SUBJECT: Engineering Review Comment
Mountain View Electric Association Inc. (The Association)

Project Name: Monument Academy – Minor Subdivision

Project Number: MS2110

Description: Proposed development of 1 lot and 4 tracts in approximately 62 acres located off at the southeast corner of State Highway 83 and Walker Rd. (Highway 105) in Township 11S, Range 66W, Section 15.

# MA SUBDIVISION

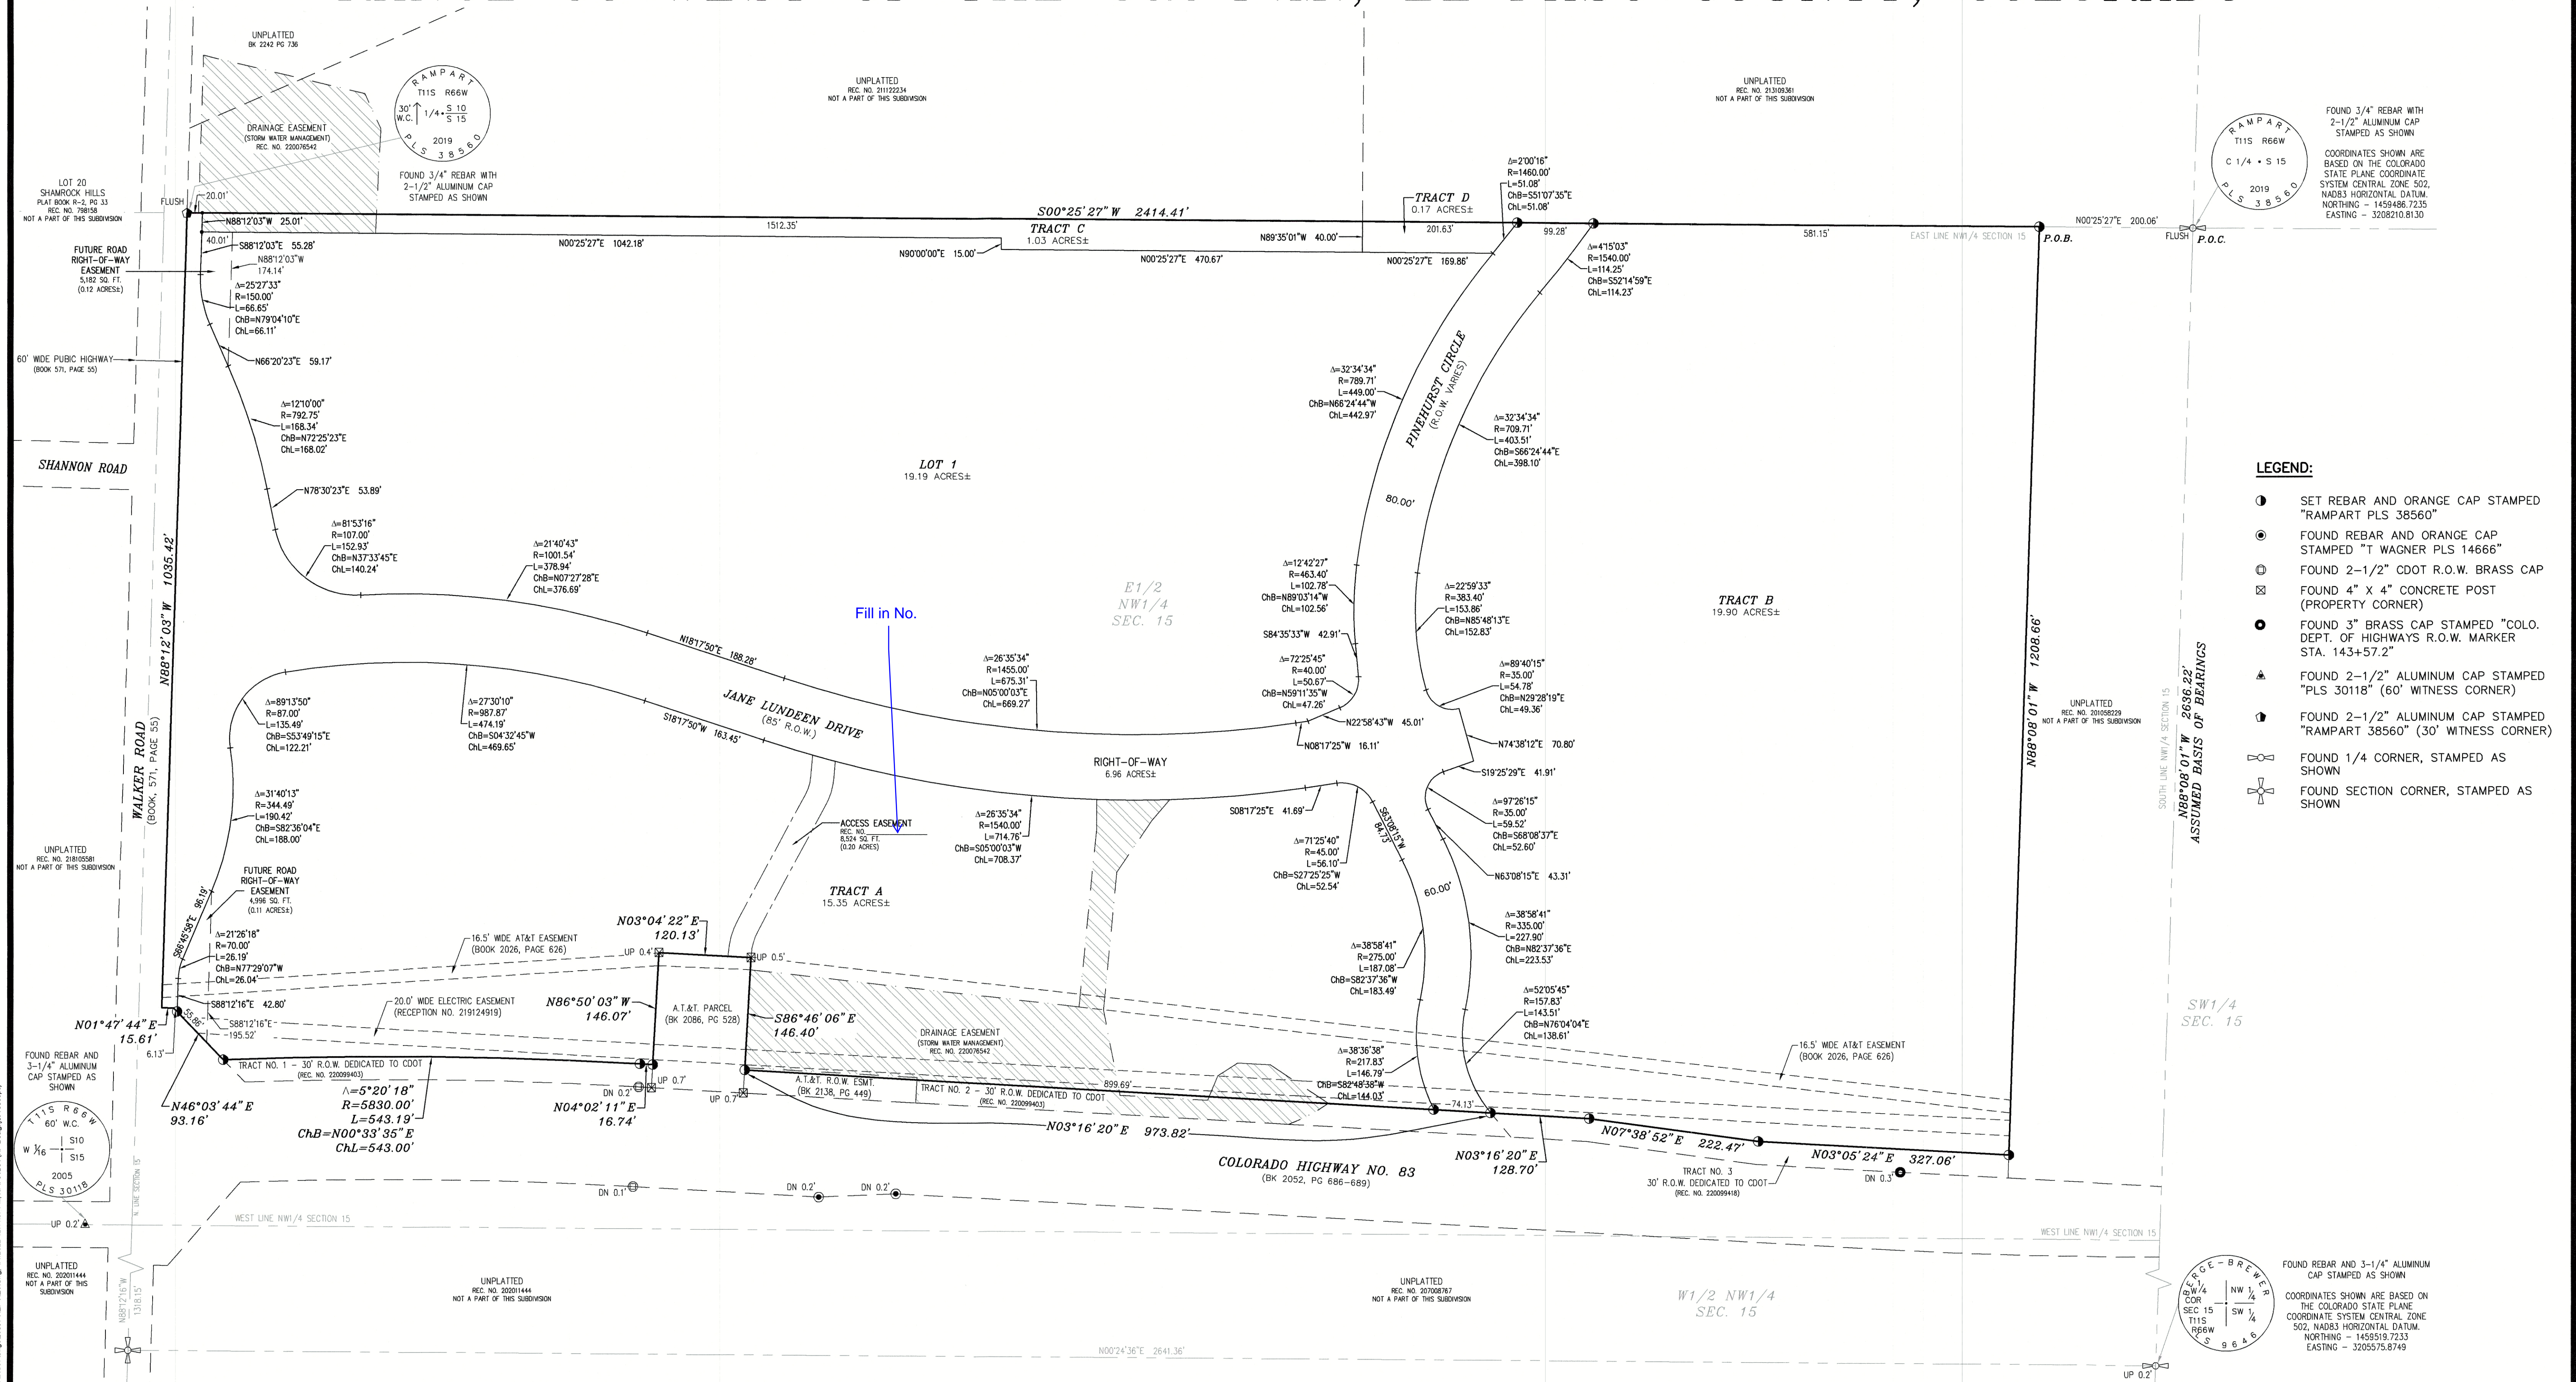
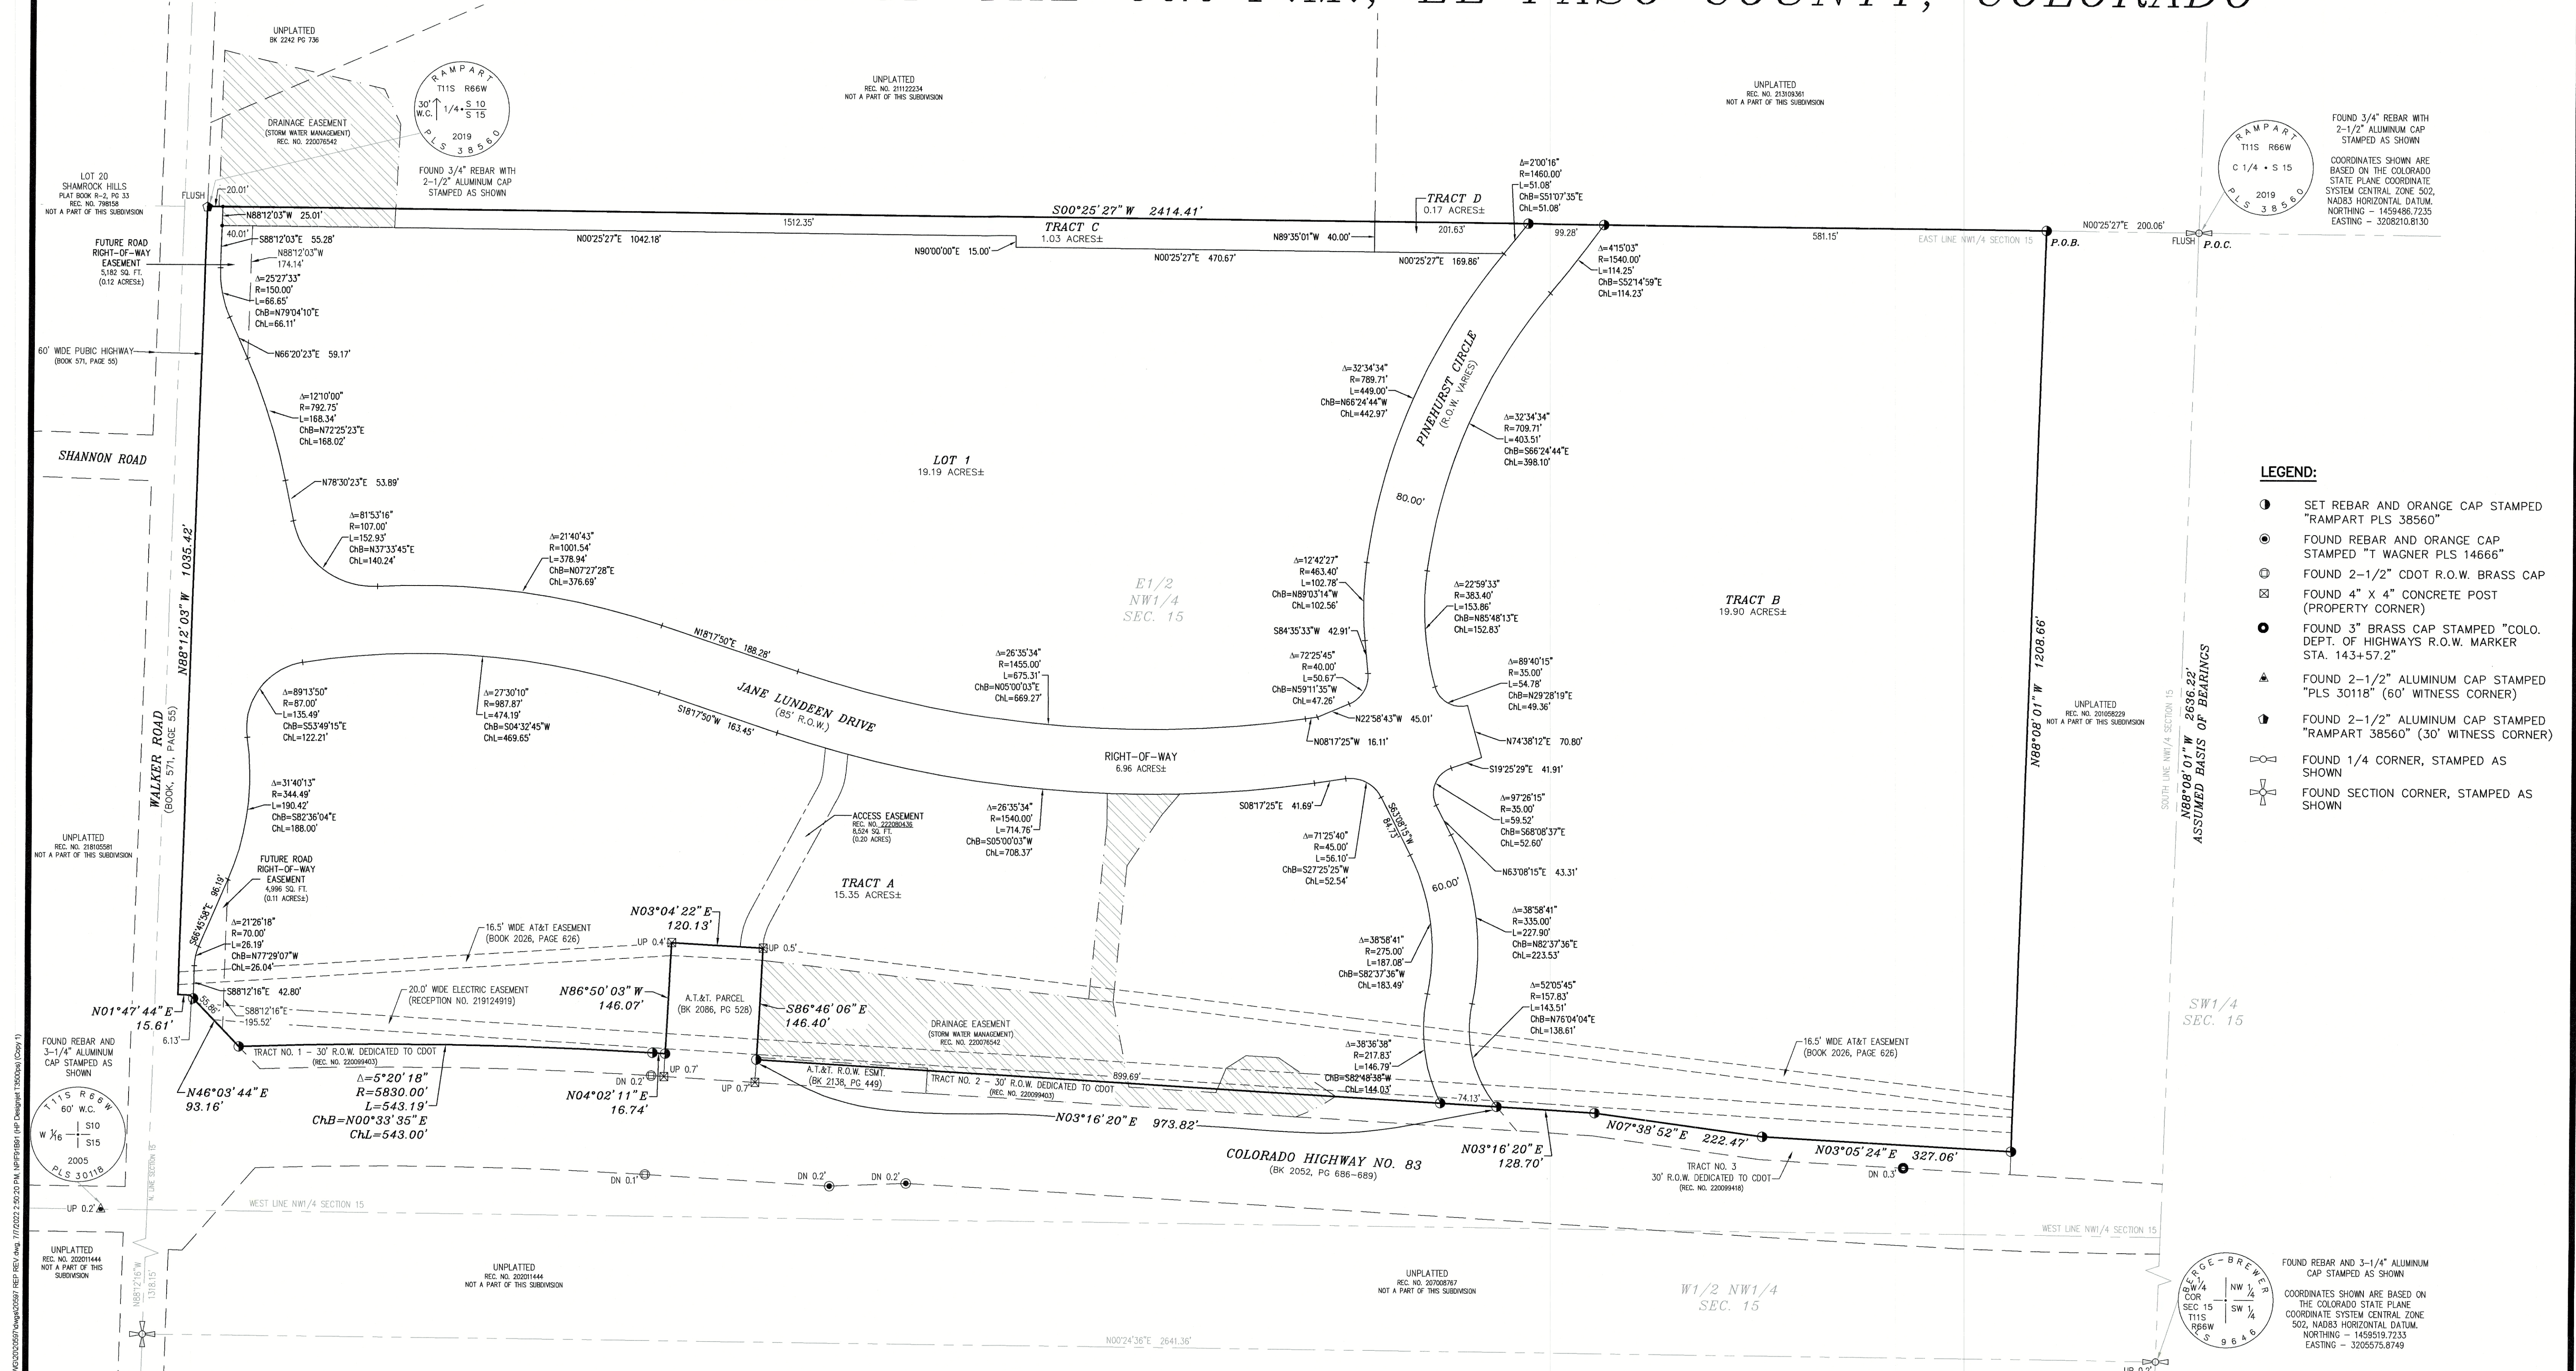
The Association requests a ten (10) foot front, side, and rear lot utility easement on the plat. The Association also requests the platting of the Association's existing facilities with easements on the plat. Additional easements may be required.
